Bourke Small Stock Abattoir (SSD 7268) - Exhibition

OEH Review - Biodiversity

OEH Review – Aboriginal Cultural Heritage

Proposed irrigation area
 Bourke Small Stock Abattoir
 Aboriginal Cultural Heritage Assessment
 Figure 1

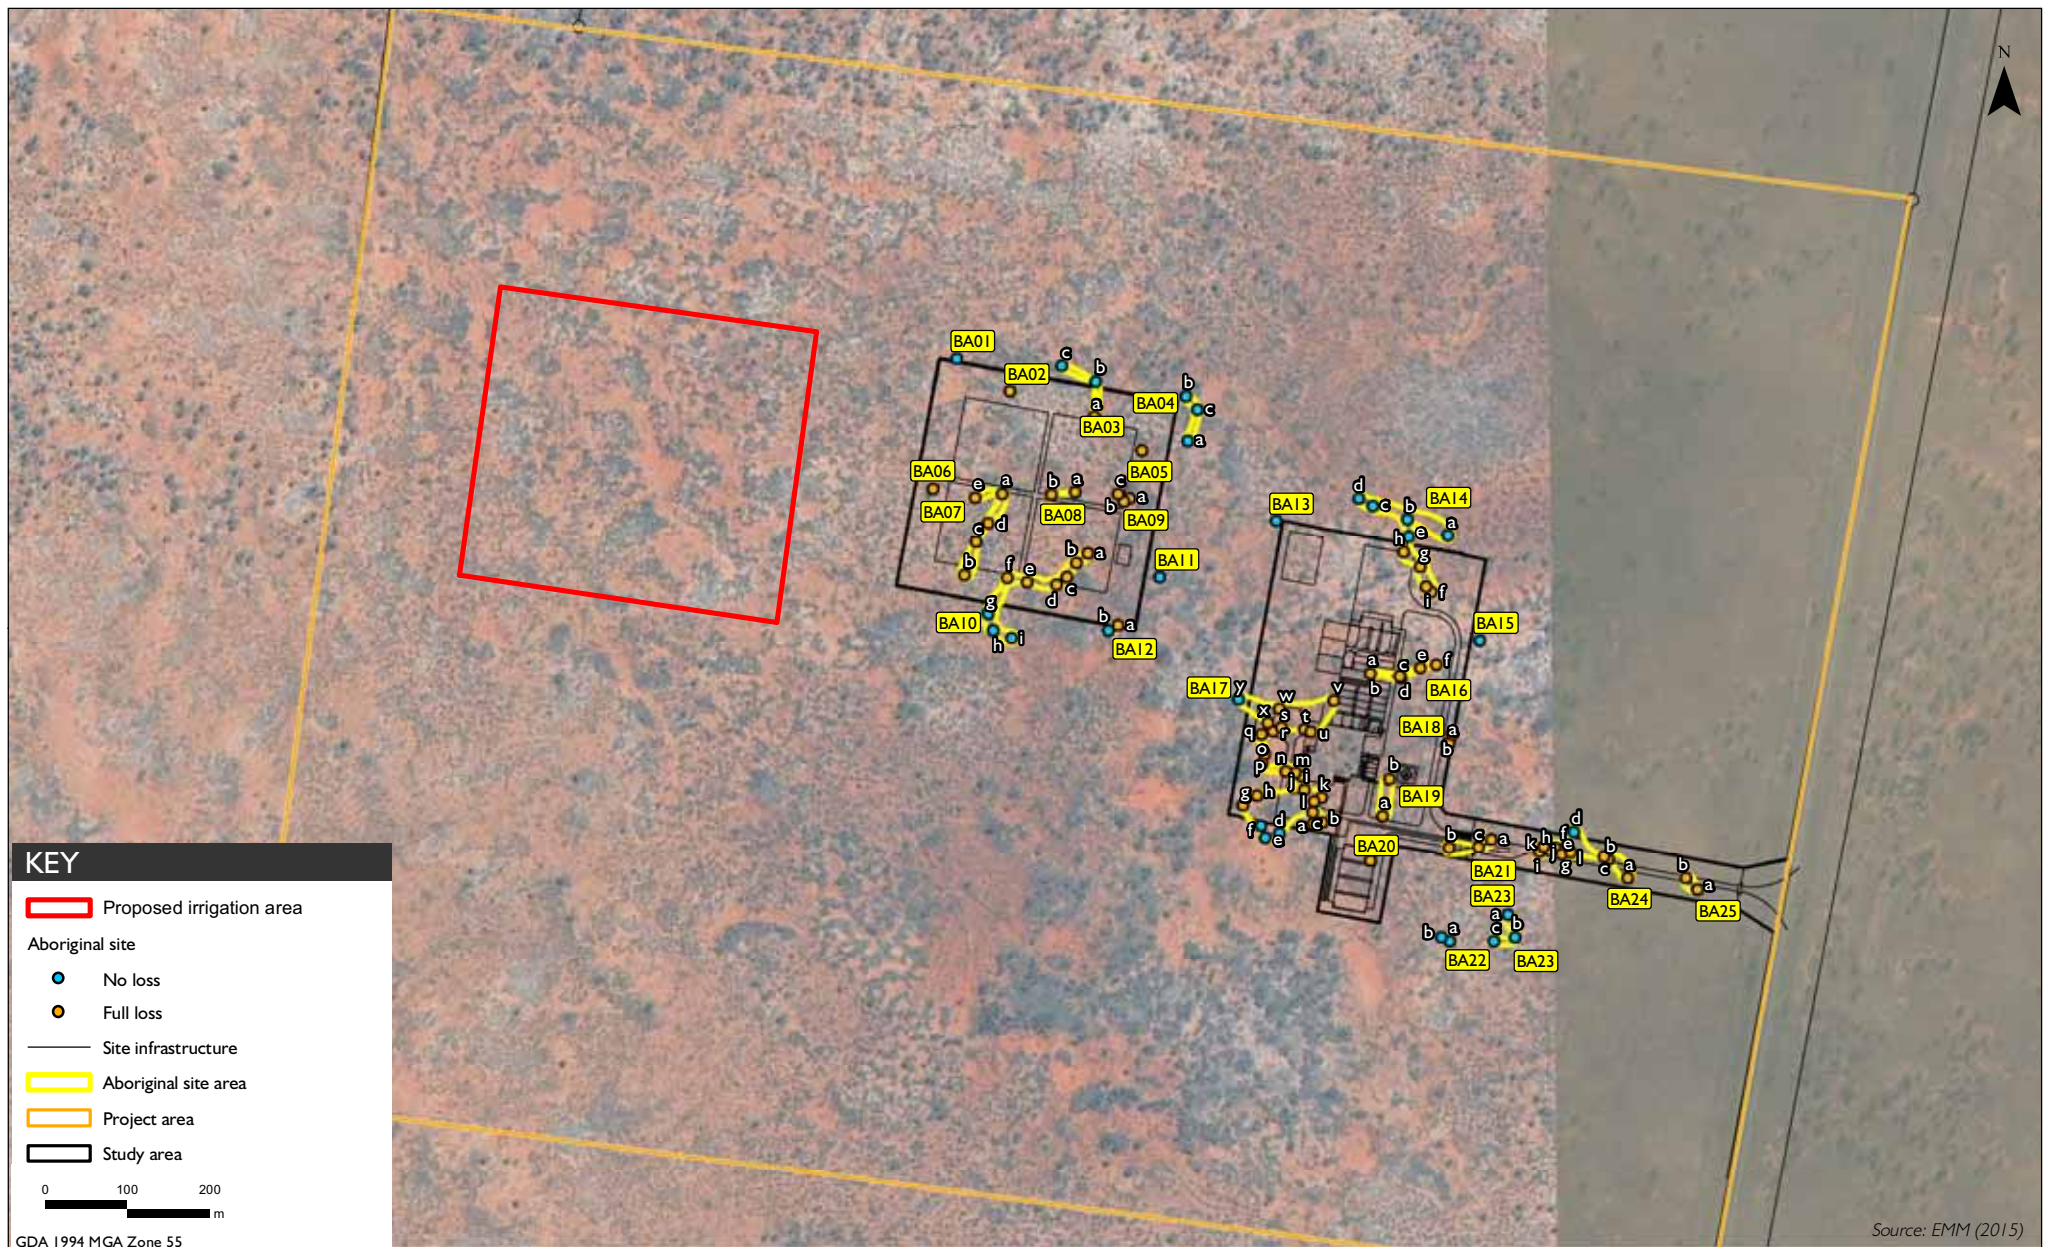
OEH note and support the assessment report recommendation for further survey work in the proposed adjacent irrigation area which has not been subject to a field survey. OEH accept the findings of the archaeology survey and subsequent site prediction estimate that the unsurveyed areas are likely to contain a low density and frequency of artefact material similar to the material recorded within the proposed footprint.

- 2.1 That surveys be conducted within the irrigation area prior to any on-ground works in the area.
